SUBJECT: BRES2210-0026
BUILDING RESIDENTIAL

Here are the results of all Inspections located at **1200 OLIVE BRANCH RD:**

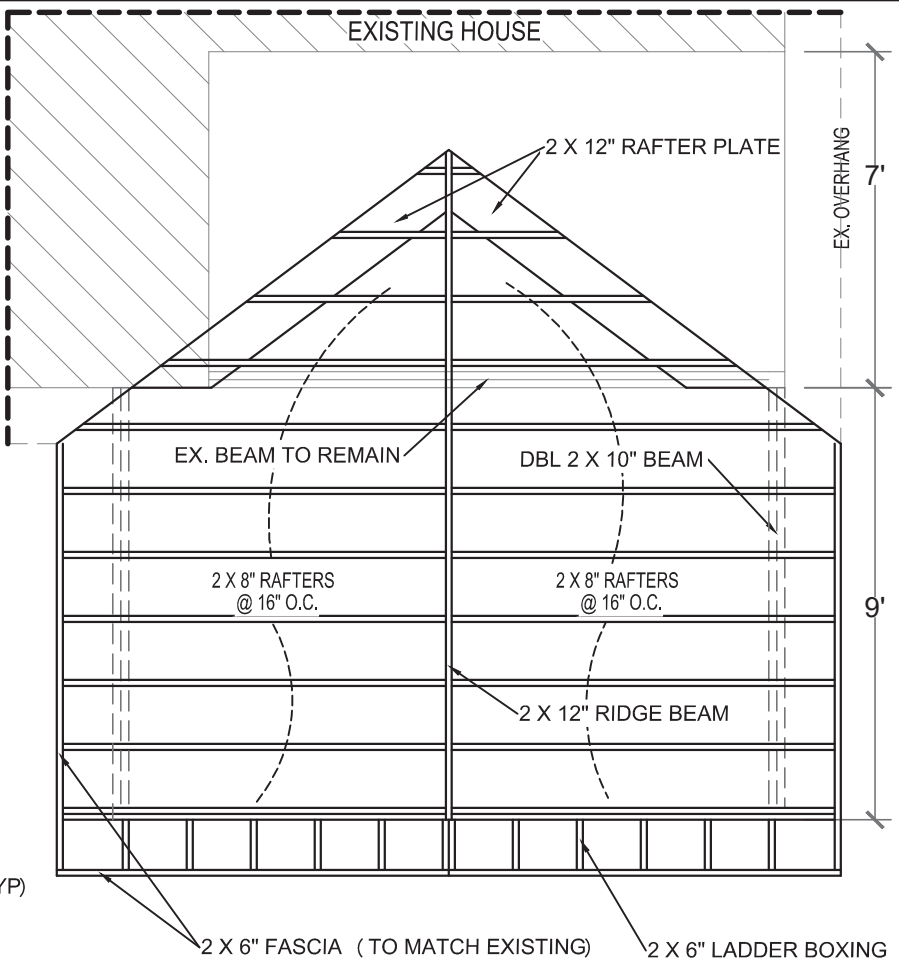
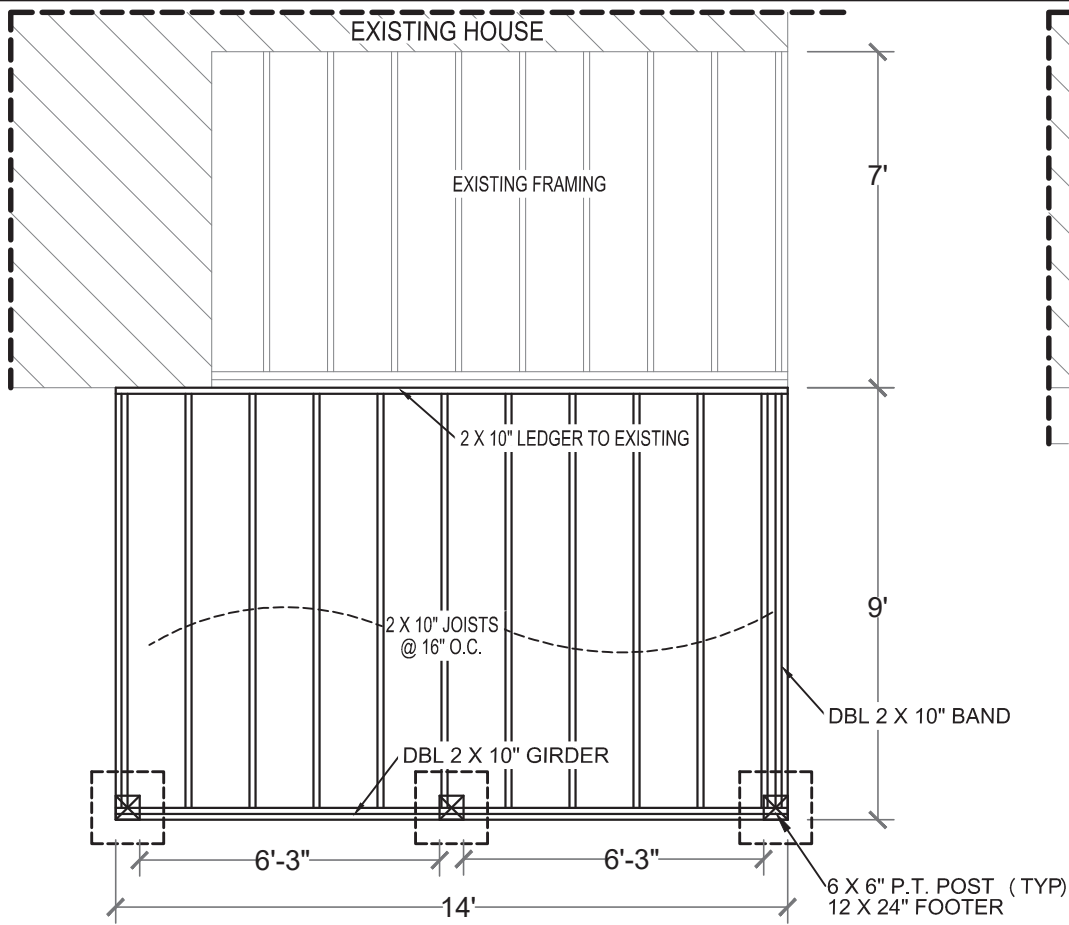
1. Rail guard posts at steps must be attached with minimum of 2- 3/8" galvanized bolts. 2. The floor joists at top of steps needs either hangers or ledger strip. 3. Need letter from the engineer on the plans for stick built roof. Plans only show posts supporting light panelized type roofing.

Roof system will need to be engineered for sunroom. The plan that was stamp by engineer and approved by central permitting has a different design than plan the field. If no ceiling joists or rafter ties are in the lower third of rafters then the ridge formed by the rafters has to be supported by a wall or girder designed in accordance with accepted engineering practice.

Engineered roof and plans
